Morecambe Offshore Windfarm: Generation Assets Environmental Statement

Chapter 8 Marine Sediment and Water Quality

PINS Document Reference: 5.1.8

Figure: 8.1 **Drawing No:** PC1165-RHD-ES-OF-DR-Z-0016

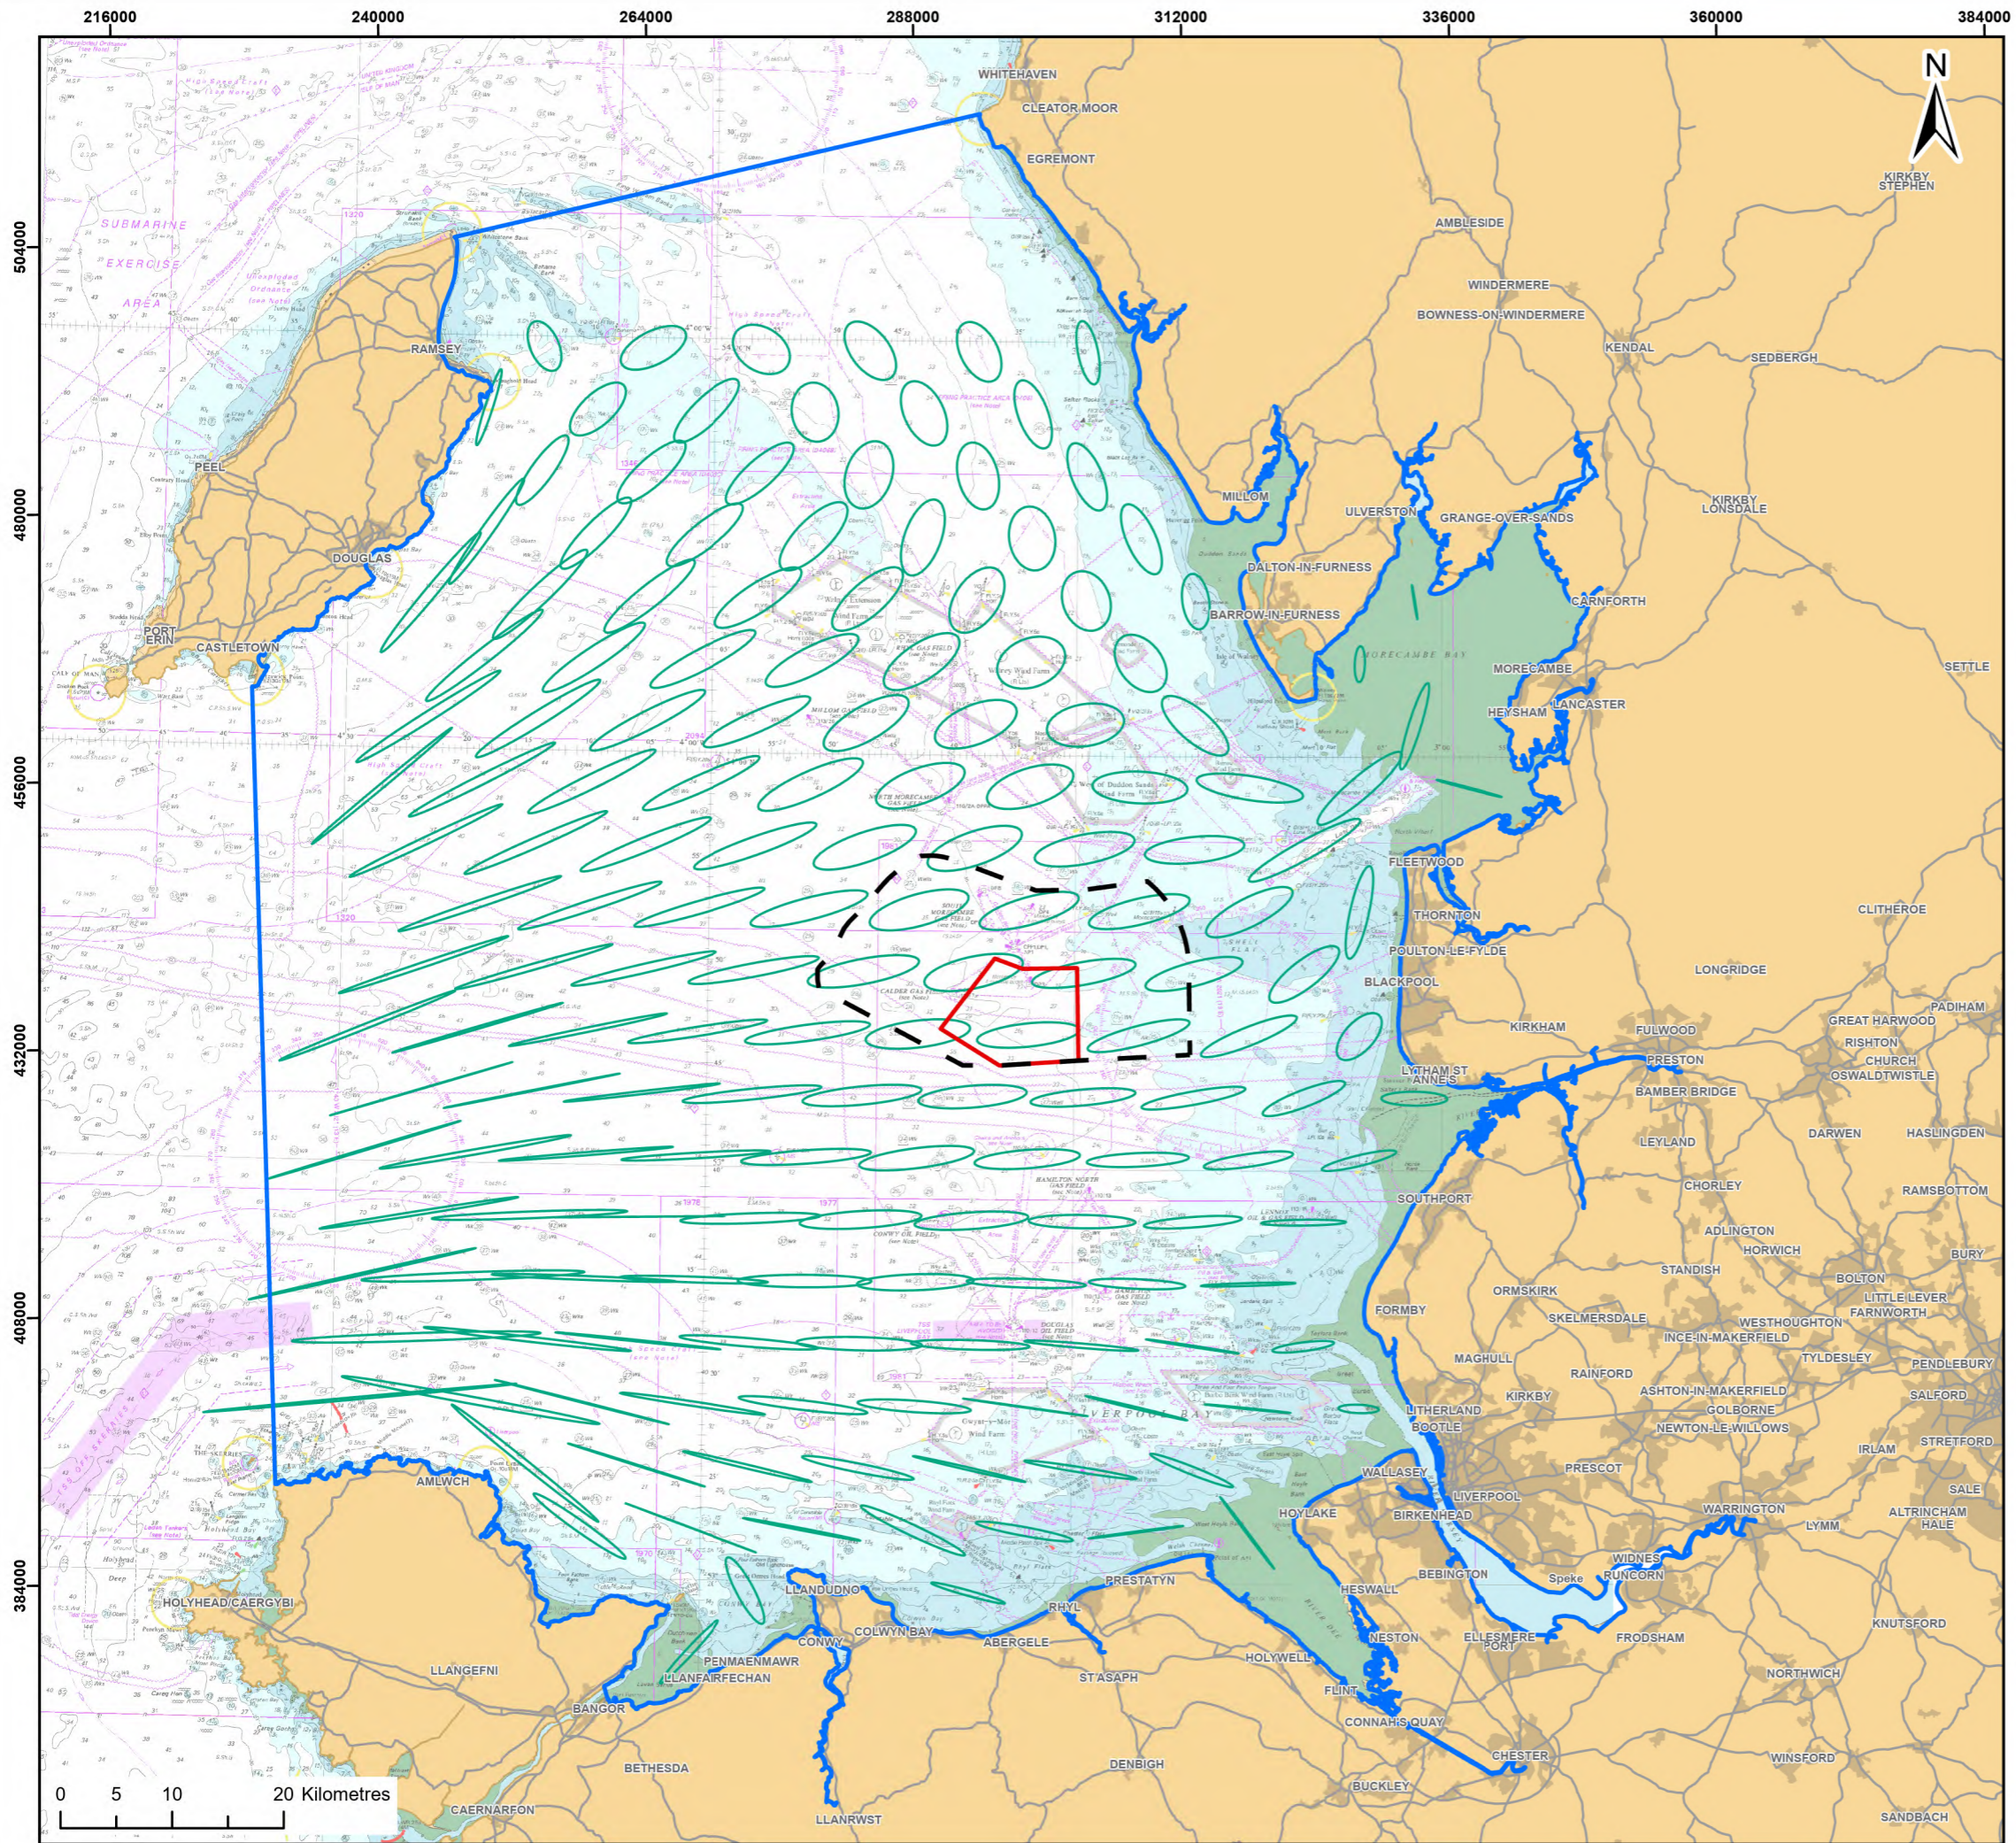
PINS (ref. 3.1.5)	2 nd August 2022	The study area is defined as the 'Morecambe Offshore Windfarm Site' as shown on Figure 8.1. However, the scoping report states that the study area also includes areas beyond the windfarm site and across the wider regional seabed and coastline. This is not shown on Figure 8.1. The ES should include a figure clearly showing the boundary of the study area and provide a justification for the final extent.	The study area is described in Section 8.3.1 and presented in Figure 8.1 .
PINS (ref. 3.2.4)	2 nd August 2022	The datasets listed are, with one exception, over ten years old and it is not clear how relevant they are to the area affected by the Proposed Development. Given the age of previous surveys within the area, the distance from the Proposed Development and the lack of information on the	Whilst some of the data used is over 10 years old, the datasets help to provide context to the site-specific survey data collected to inform the assessment, given similarities in sediment grain sizes. Emphasis in the baseline section,
